**Consultation Response from KC,
Building Control**

2025/91184 land off, Bretton Street, Savile Town, Dewsbury, WF12 9BZ

Erection of two storey industrial unit (Use Class E(g)(iii)), with associated car park, service area and other associated works

Responding Ref: 2025/01146

Project No: 2024  
Enquiry 51  
Project Title: proposed site location (overlaid onto with survey contours)  
Reviewed By: MC  
Scale: 1:500 @A1 size  
Date: 7/1/2025

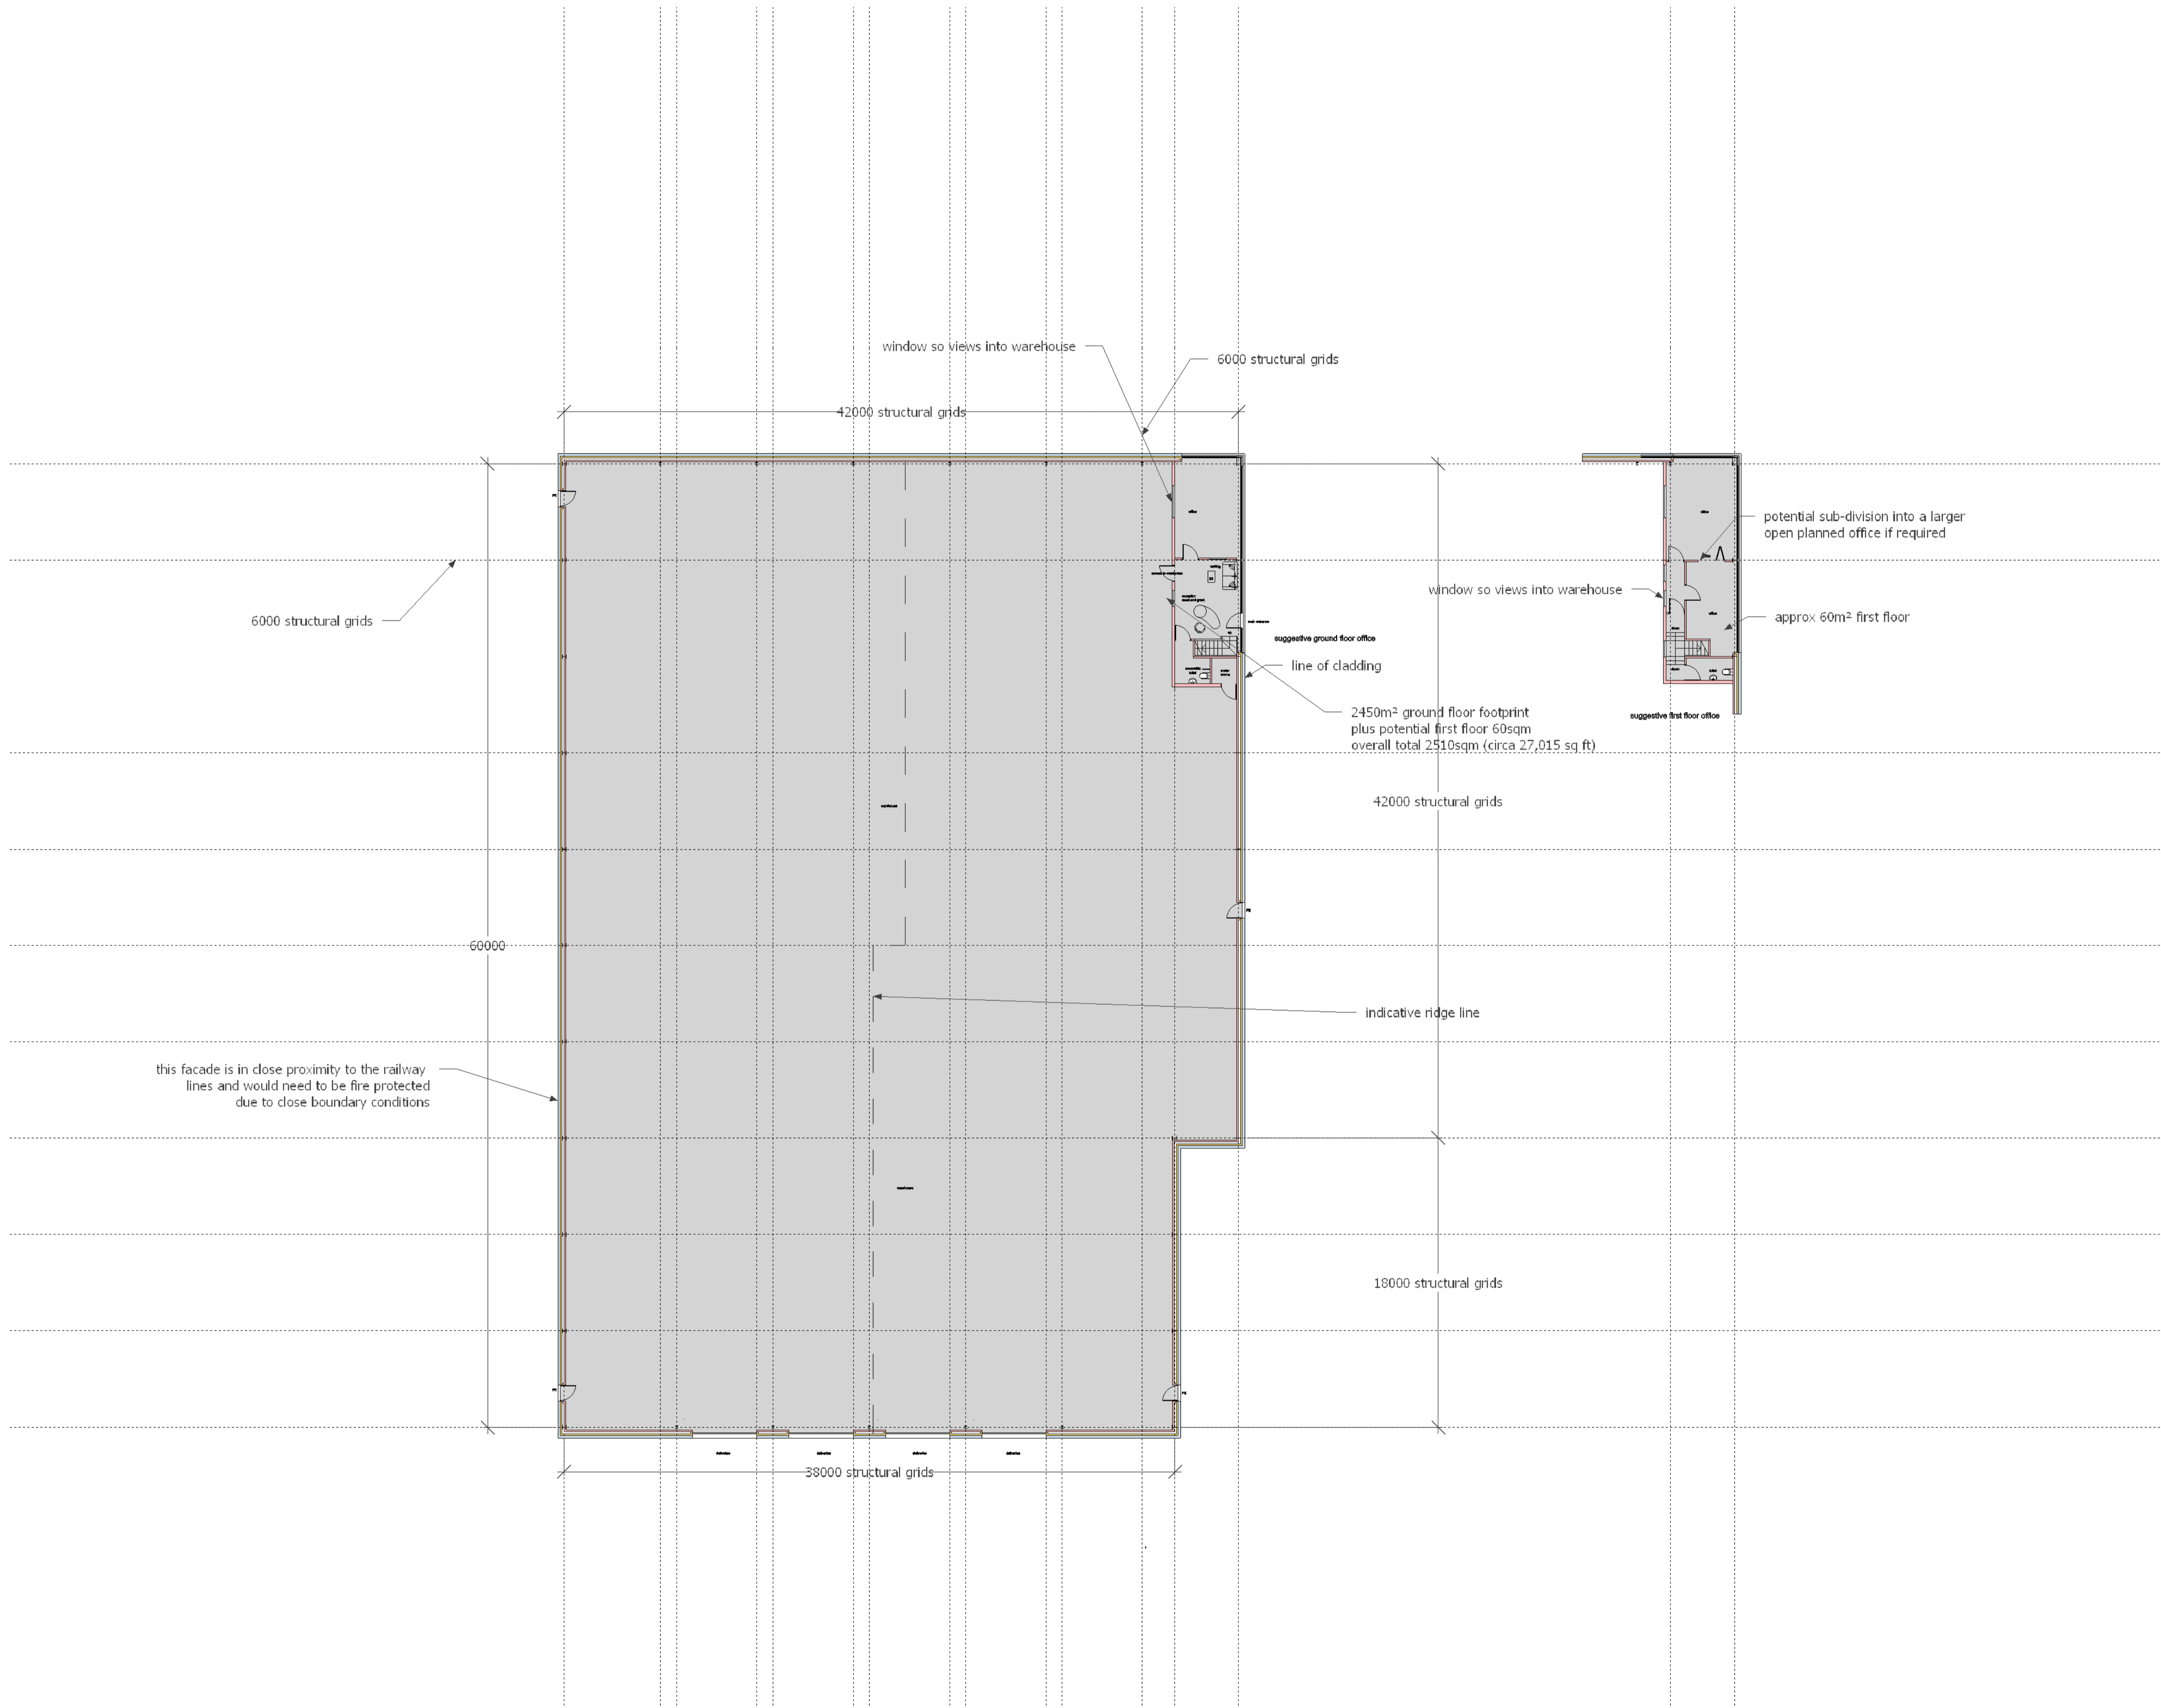
- 3) A significant retaining wall is noted on the site plan adjacent the Highway- Bretton Street. It would appear this is not part of the proposed unit's structure therefore not controlled under Building Regulations- Consultation with Highways regarding their requirements would be recommended.

- 4) A 600 diameter SW public sewer is noted crossing the site- it would be advised the applicant is directed to Yorkshire Water for their requirements prior to the submission of a BR Application. It is also noted from the snip below a pipeline crossing the canal- also visual on google street view- this will require investigation as may cross the site and which infrastructure does it belong to.
